Mountain View Electric Association, Inc. (MVEA) has these comments about the following:

Project Name: Lorson Ranch East, Filing #4

Project Number: SF 198

Description: Lorson, LLC is requesting approval of Lorson Ranch East, Filing #4 with 246 lots and 9 tracts on a 58.471 acre parcel. This subdivision is located south of Fontaine Blvd. and east of Jimmy Camp Creek in Section 13 and 23 and 24, Township 15 South, Range 65 West, El Paso County.

SHEET 1 OF 9

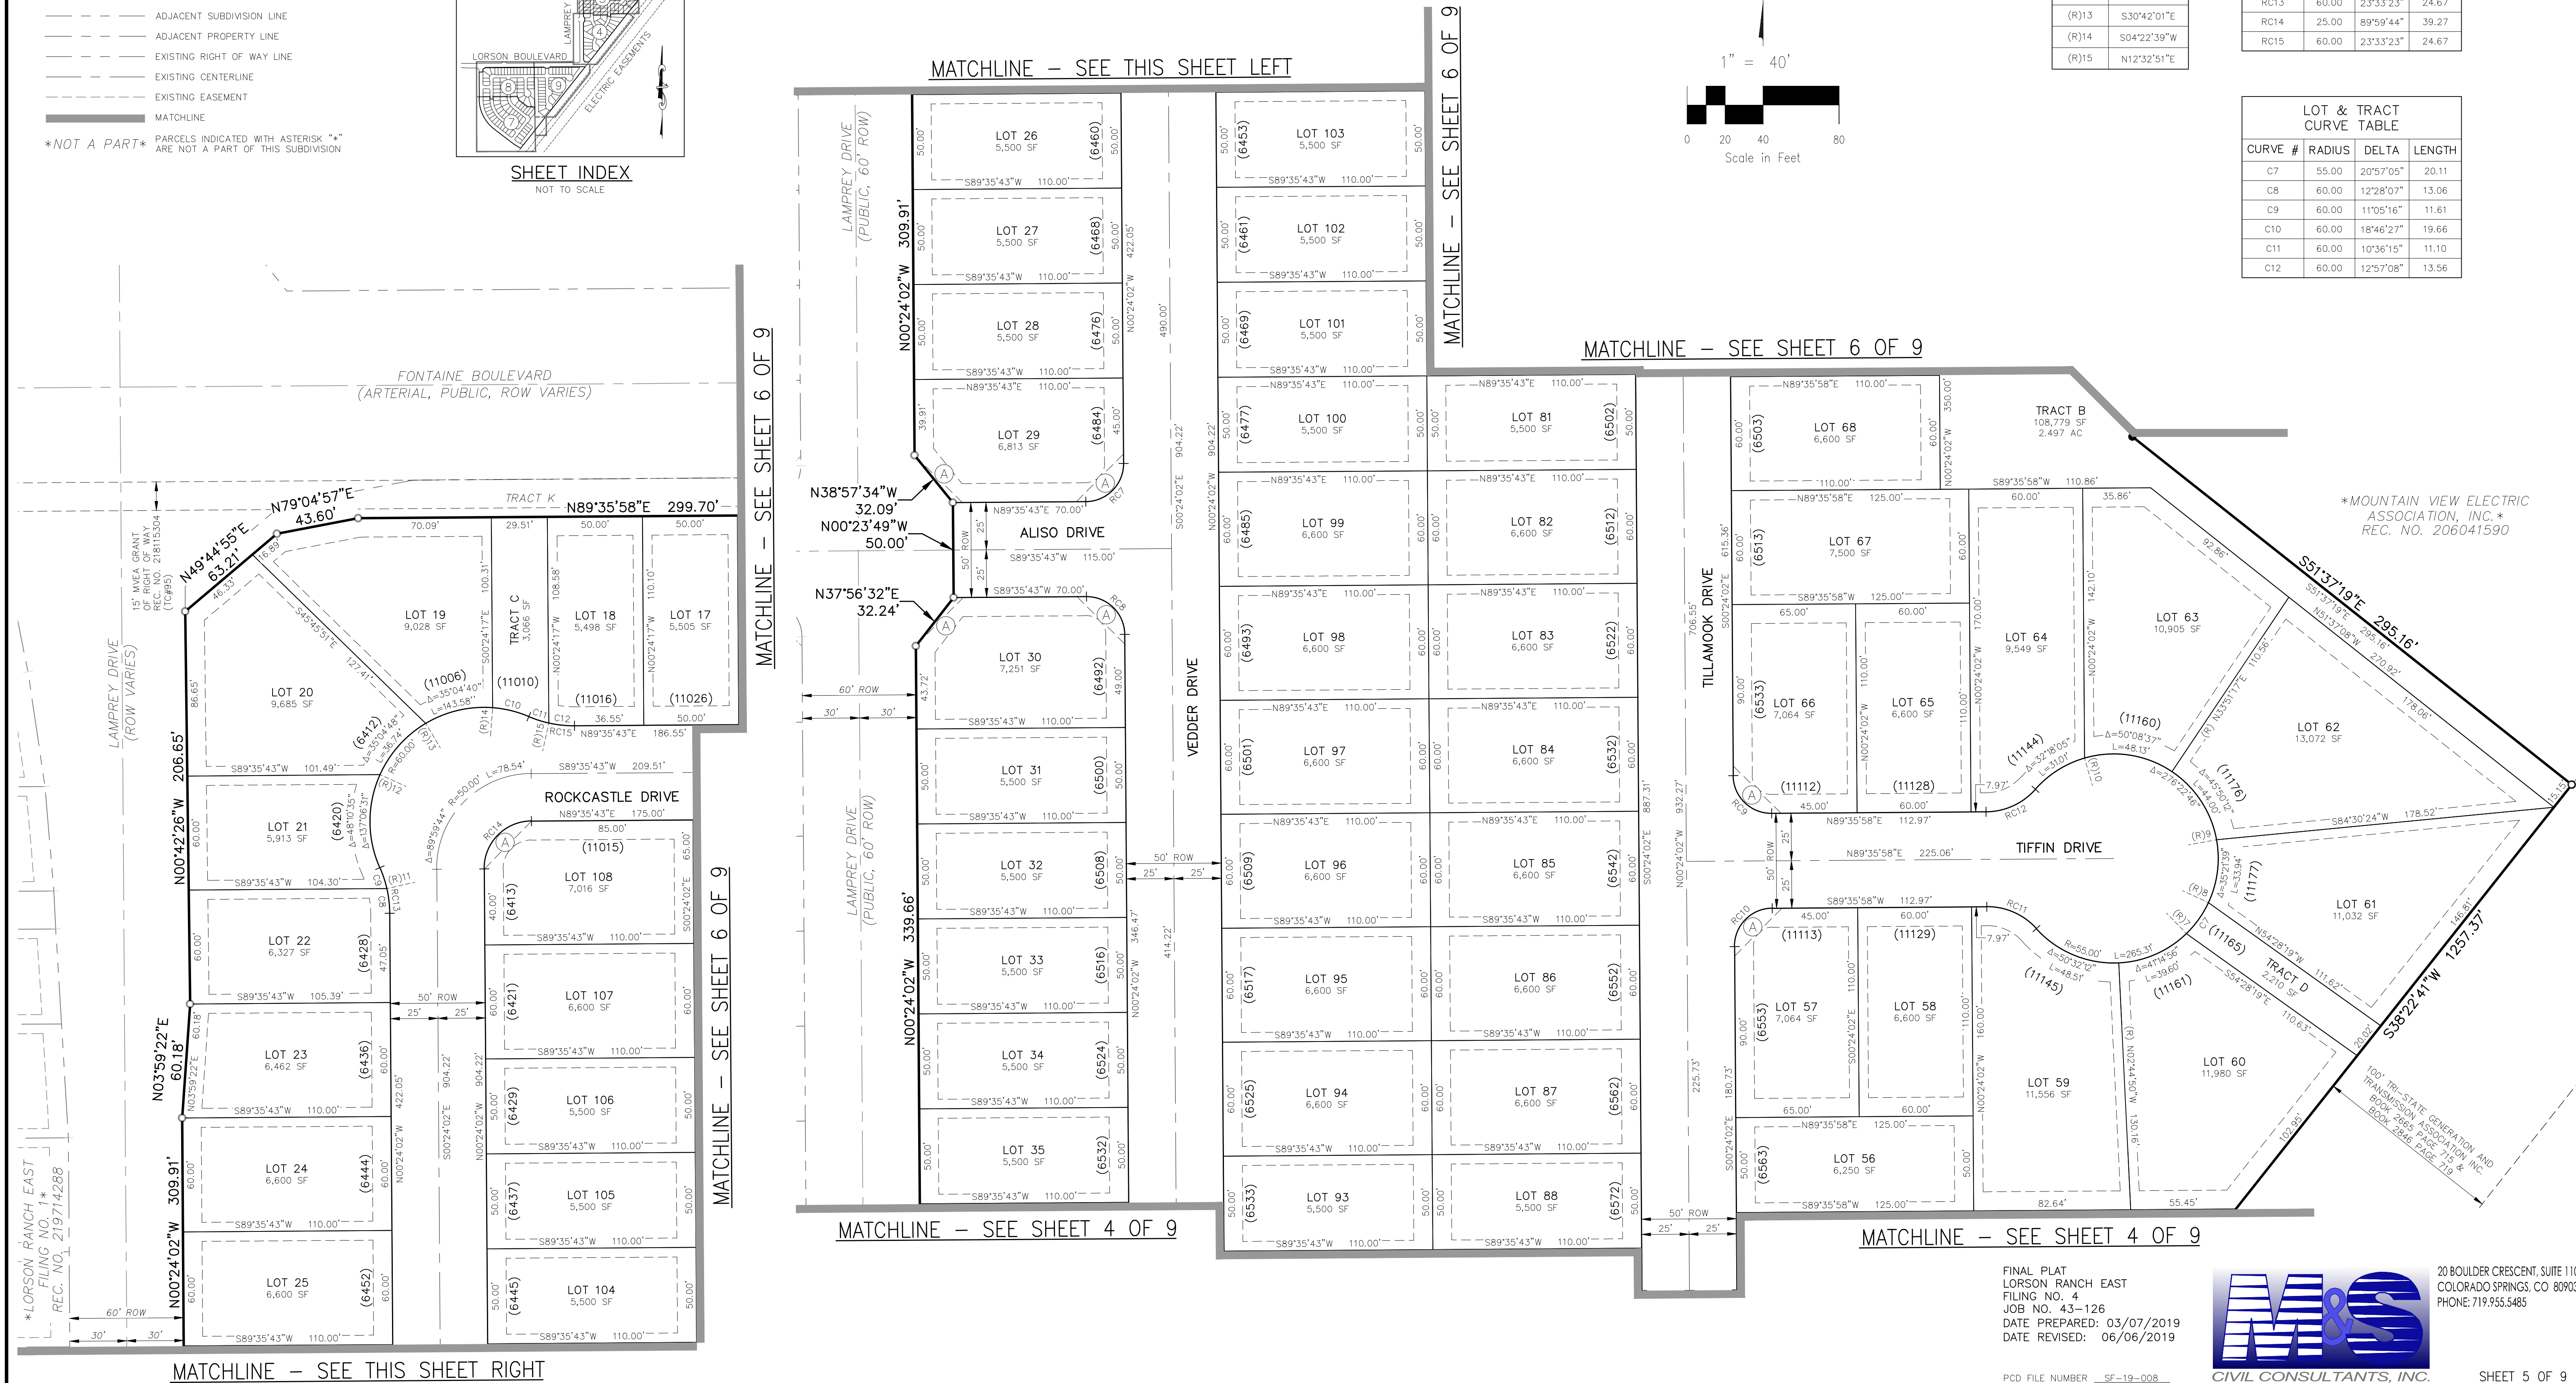
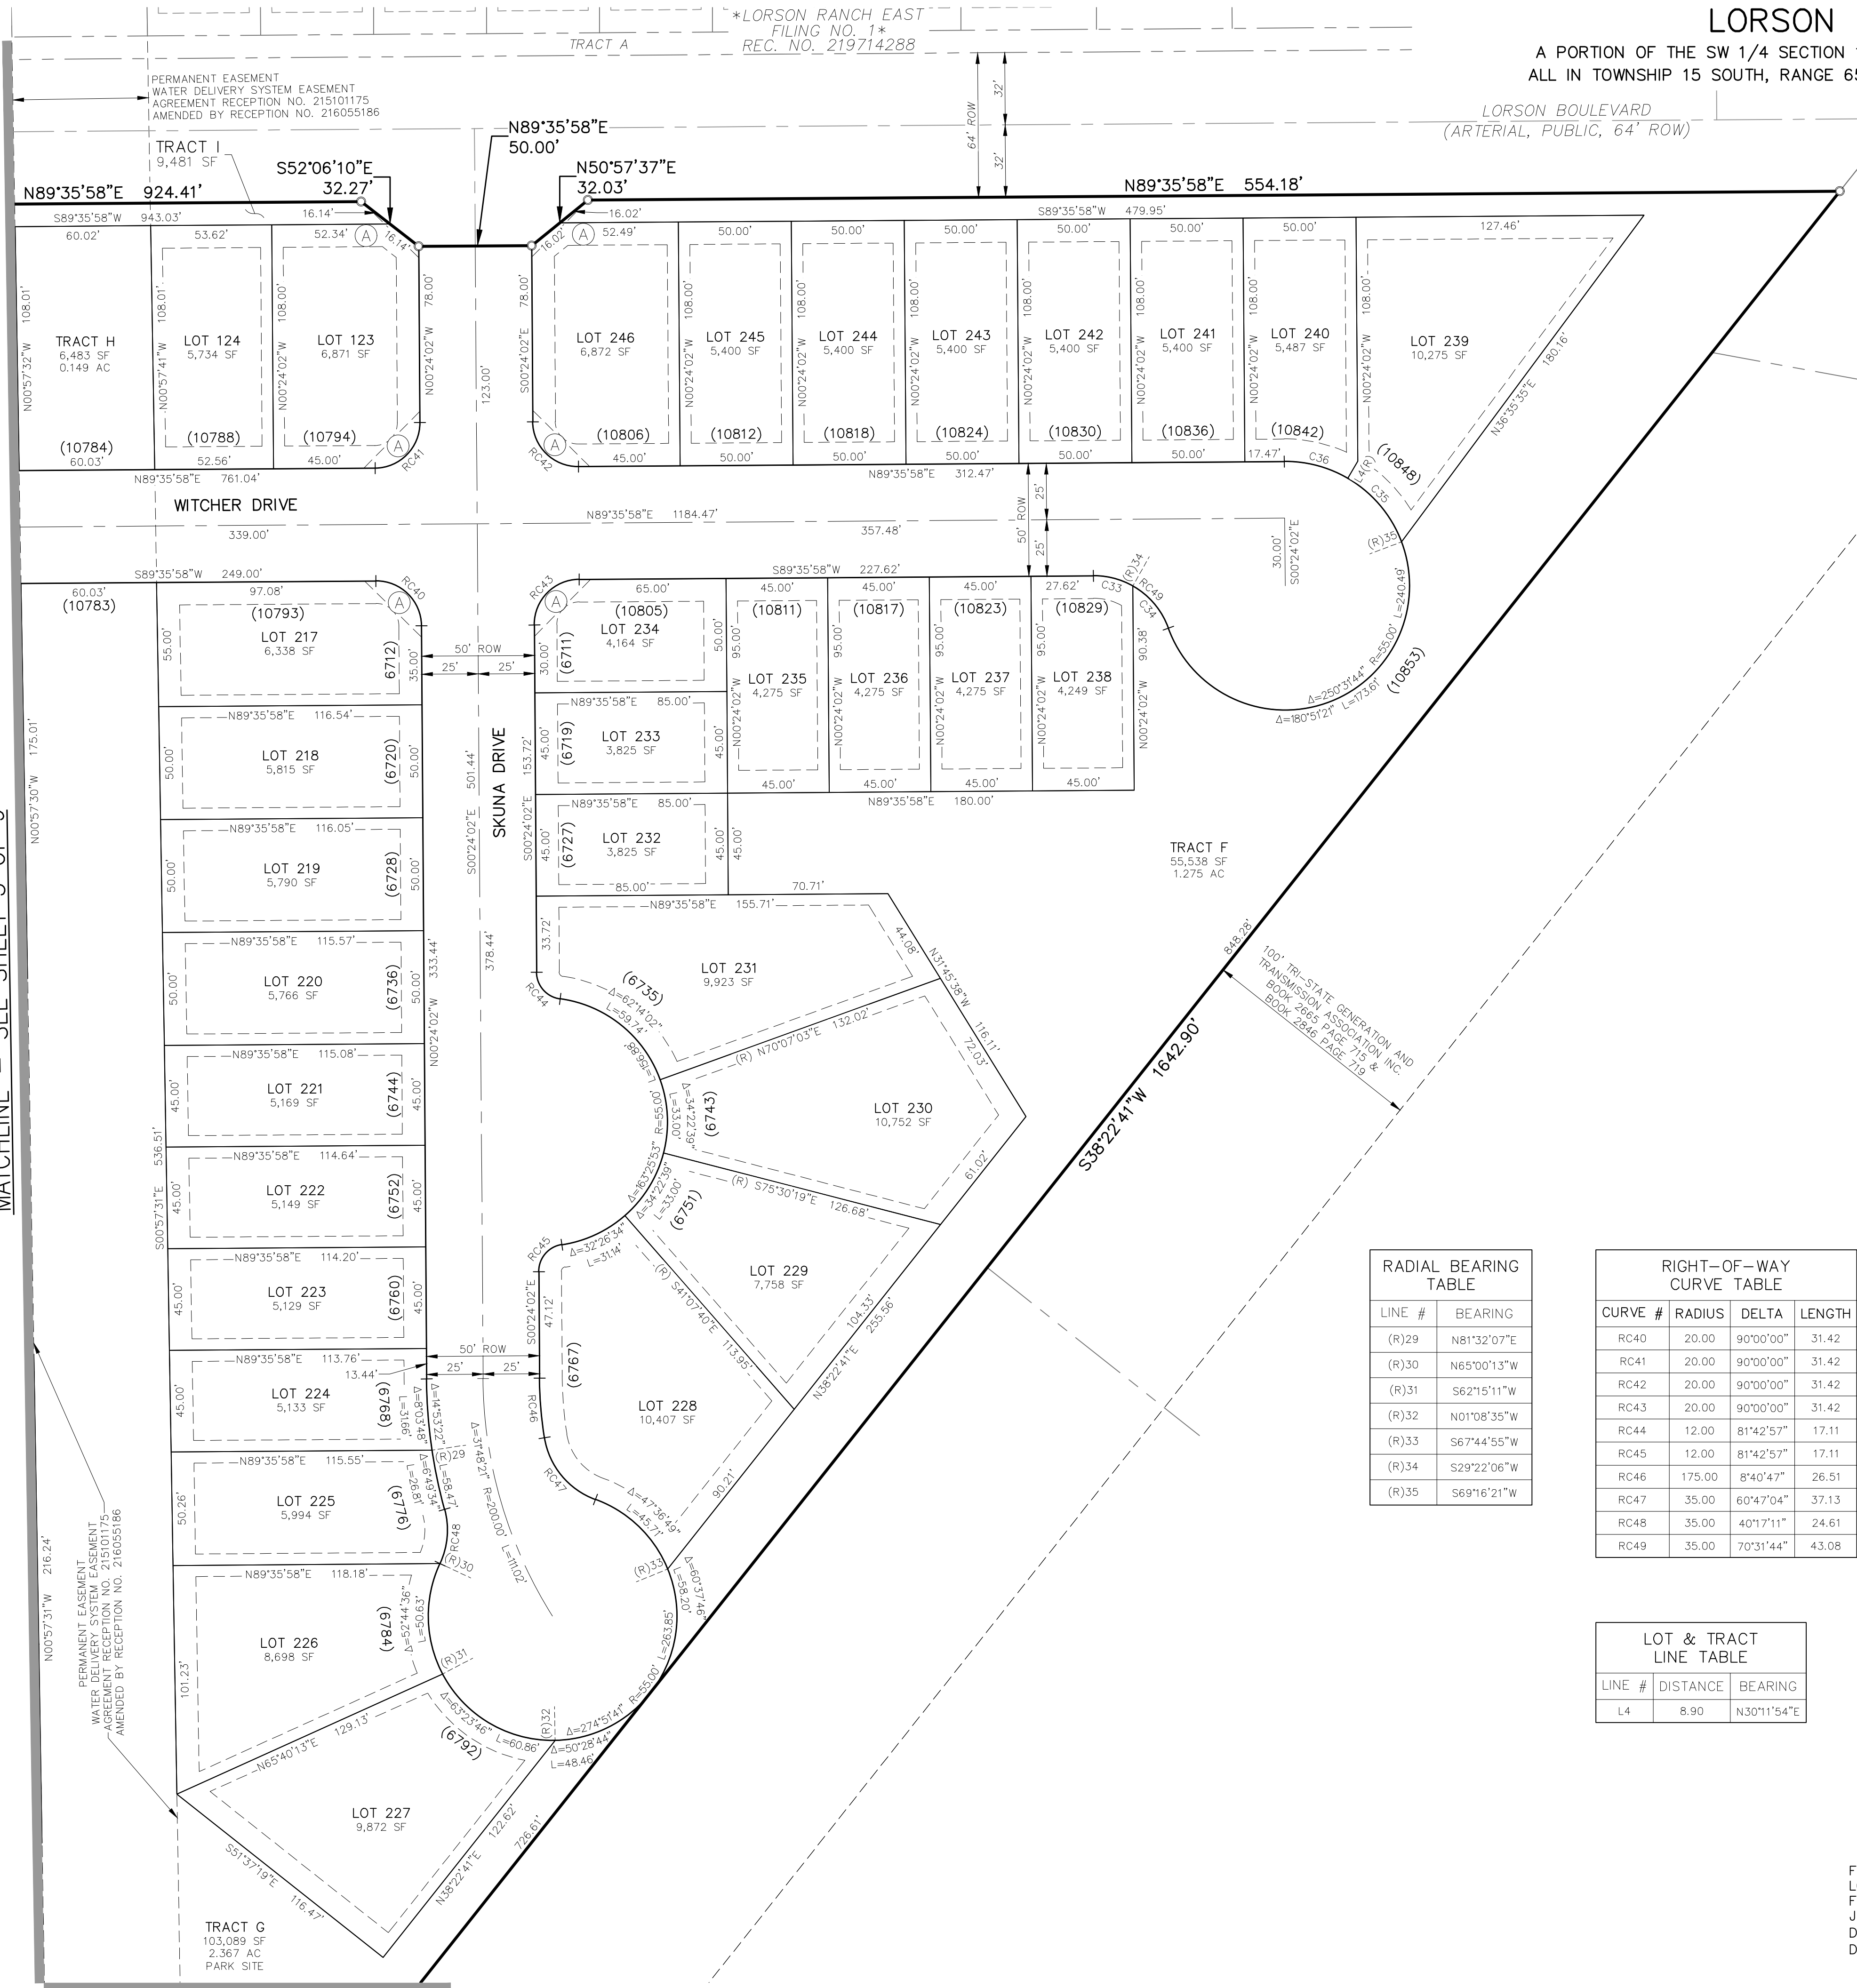
MVEA notes utility easements show on the plat of ten (10) foot front lot and tract utility easement, five (5) foot each side lot line, and ten (10) foot rear lot line easement along with a twenty (20) foot exterior easement on plat. If open space, drainage and landscape tracts are designed in this subdivision MVEA requests these areas be listed to include utilities.

Additional easements may be required once a review of civil drawings with grading and erosion plan is provided to MVEA. If the requested utility easement(s) are not provided on the final plat MVEA may not be able to serve this filing of the subdivision.
